**West Yorkshire Police  
Kirklees District**

To: William Simcock Kirklees Council Planning Services	Ref: 2021/91975 Date: 9 <sup>h</sup> June 2021
--	---

**Site Location: 1145 Manchester Road, Slaithwaite, Huddersfield, HD7 5JY  
Application type: Residential units**

Proposed Site Plan 1:100

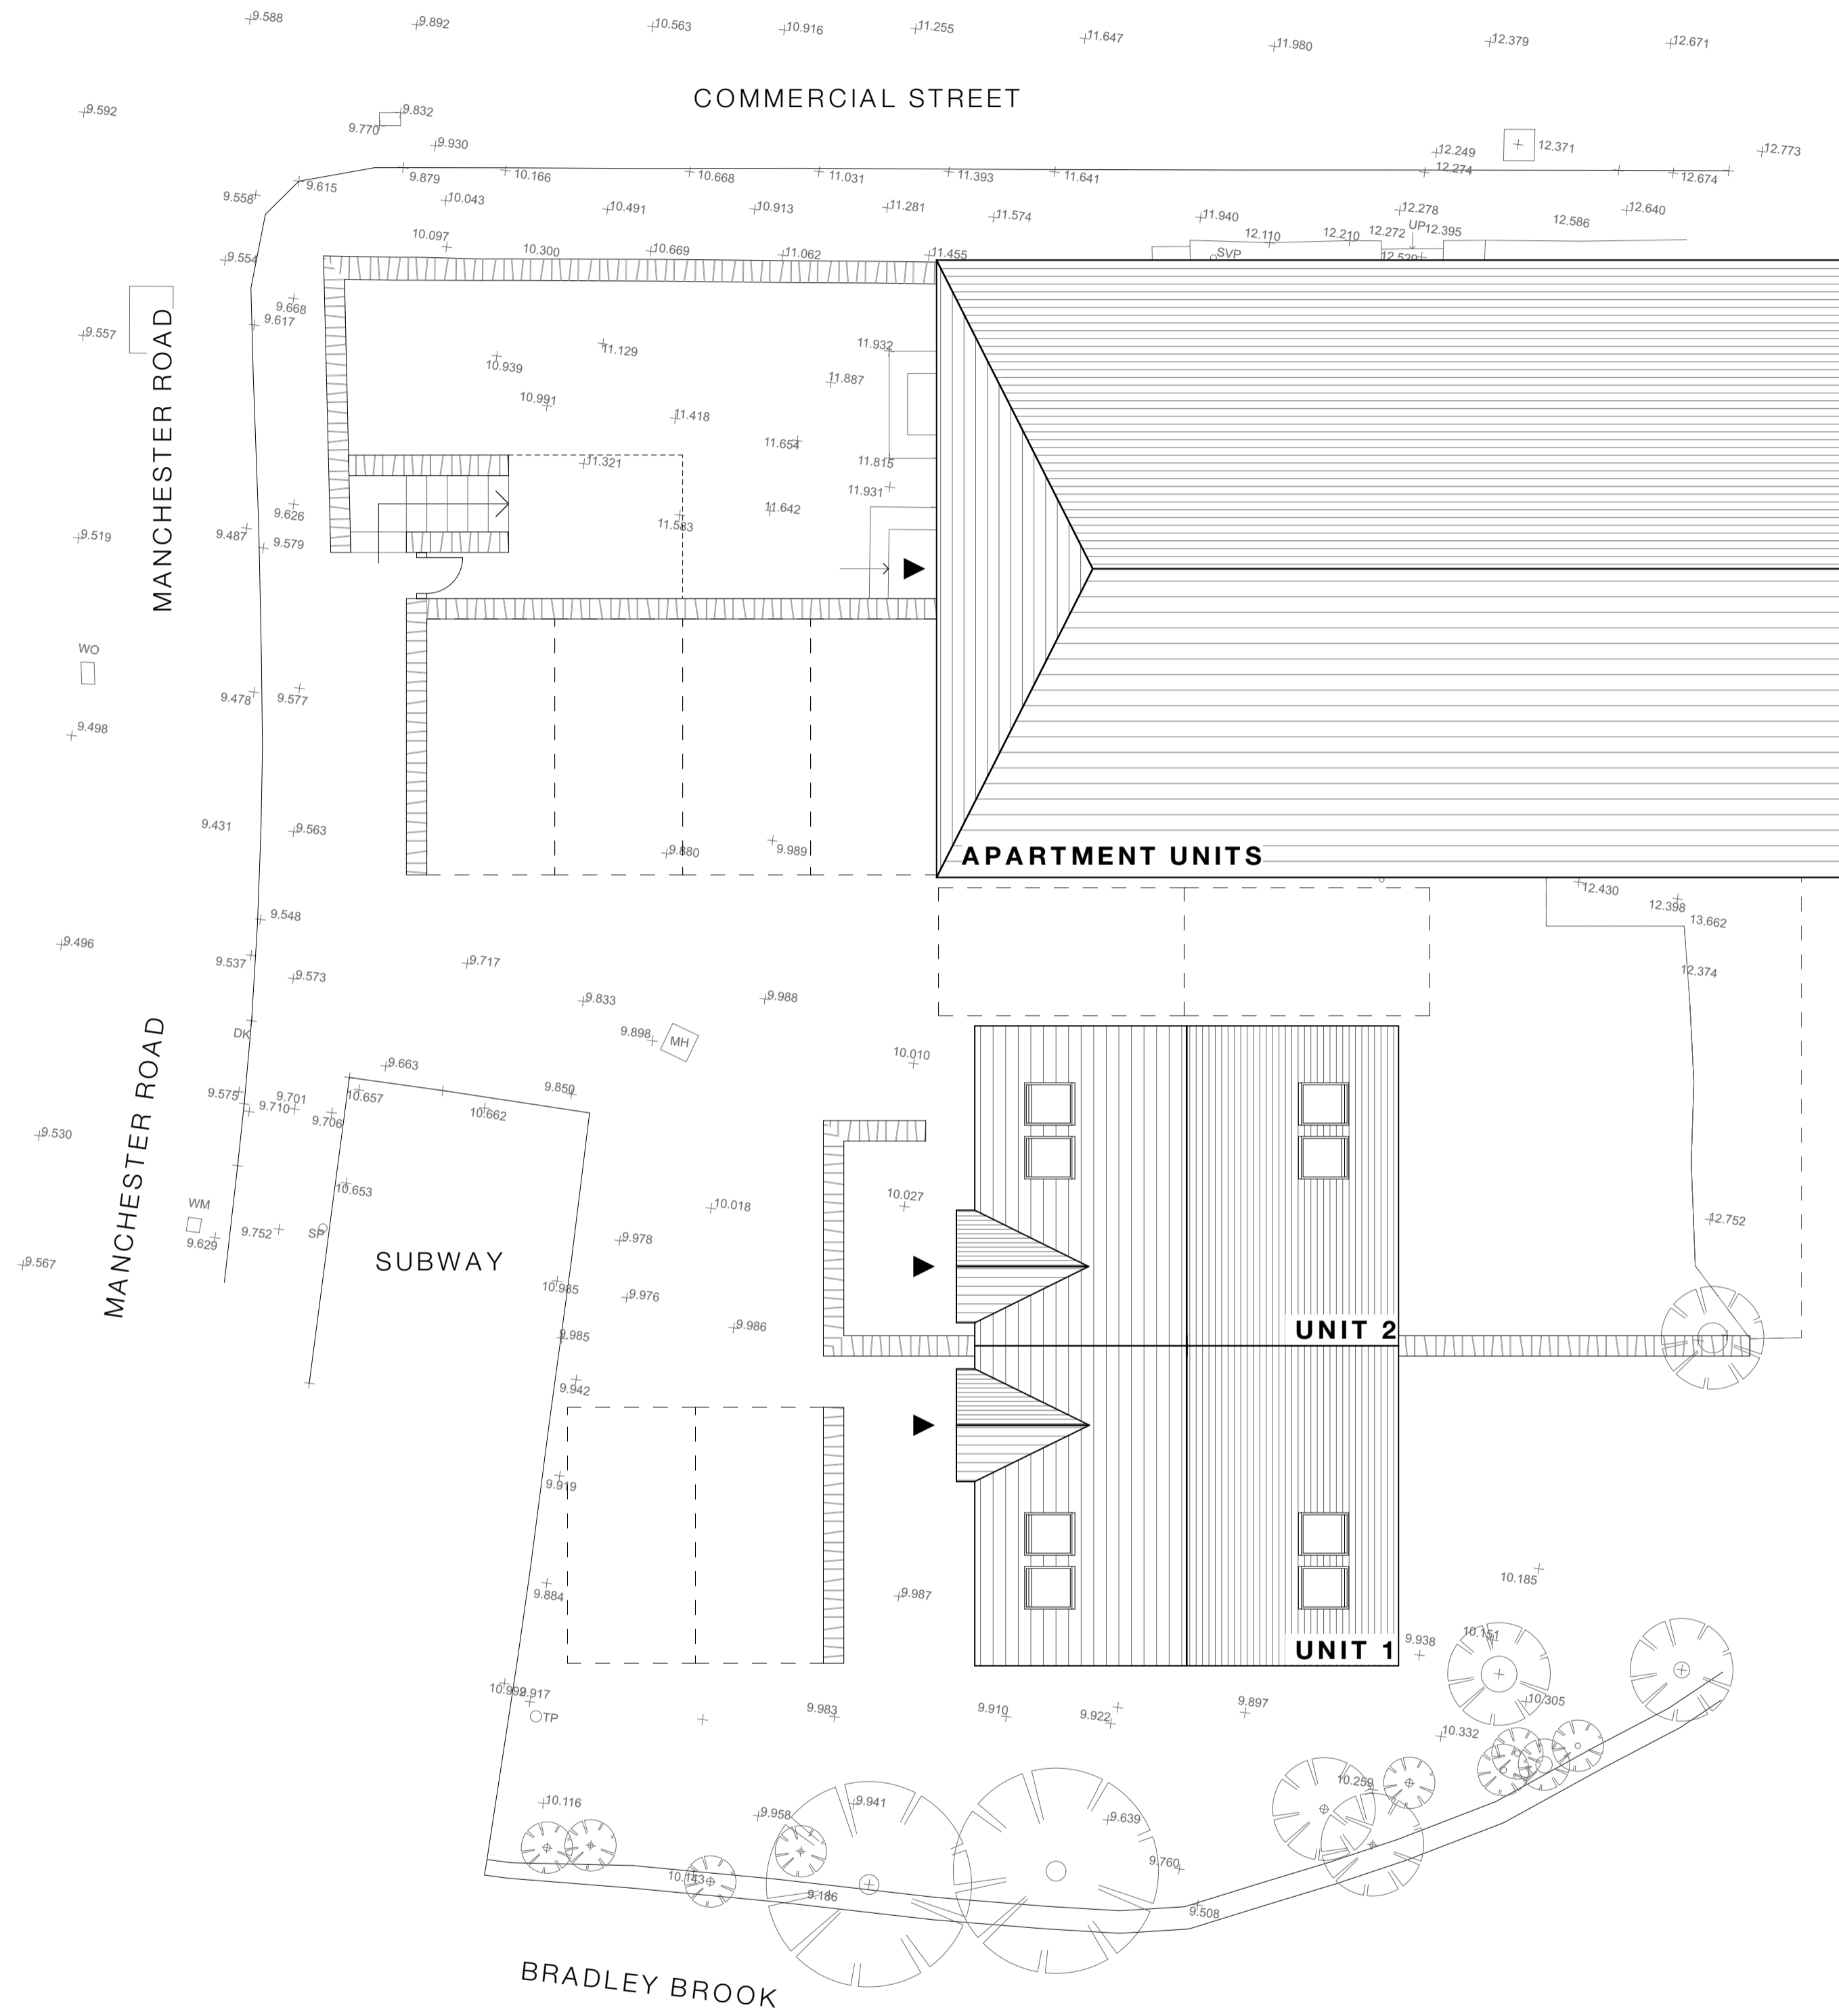
It is recommended the rear boundary treatments for each plot are to a height of 1800mm such as masonry materials, close boarded timber fencing or other durable materials. Rear plot dividers in height of 1800mm consisting of the same material as above should be installed between properties.

Access must be restricted from the front of each plot into the rear garden by installing a 1800mm high lockable gate. This gate should be positioned near to the front building line to eliminate recesses and to increase natural surveillance restricting unauthorised access.

Plots with open front gardens, should have a marked boundary that clearly distinguishes the private space of the garden, from the public space outside it. This should consist of hedge / low wall / fence / railings of around 1m in height.

Plot dividers need to be tall and substantial enough to provide both privacy and security. Closed boarded timber fencing should be provided to a minimum 1.5m in height, and include privacy screen (a section of higher fencing) of 1.8m in height projecting out from the building for about 2m, to provide a private amenity area adjacent to the home.

Gates to the side of the dwelling that provide access to rear gardens or yards must be robustly constructed, be the same height as the fence (minimum height 1.8m) and be capable of being locked (operable by key from both sides of the gate). Such gates must be located on or as near to the front of the building line as possible.

Provision should be in curtilage parking or within view of the car owner's home. Rear parking court areas hidden from view behind garden fencing are unacceptable. They are known to become associated with nuisance and anti-social behaviour as well as increasing the opportunity for car crime and rear access burglary.

Refuse bins must be placed behind a locked gate within the rear garden. These must not be sited near ground floor windows, low roofs or boundary fences, as they will provide a climbing aid for offenders.
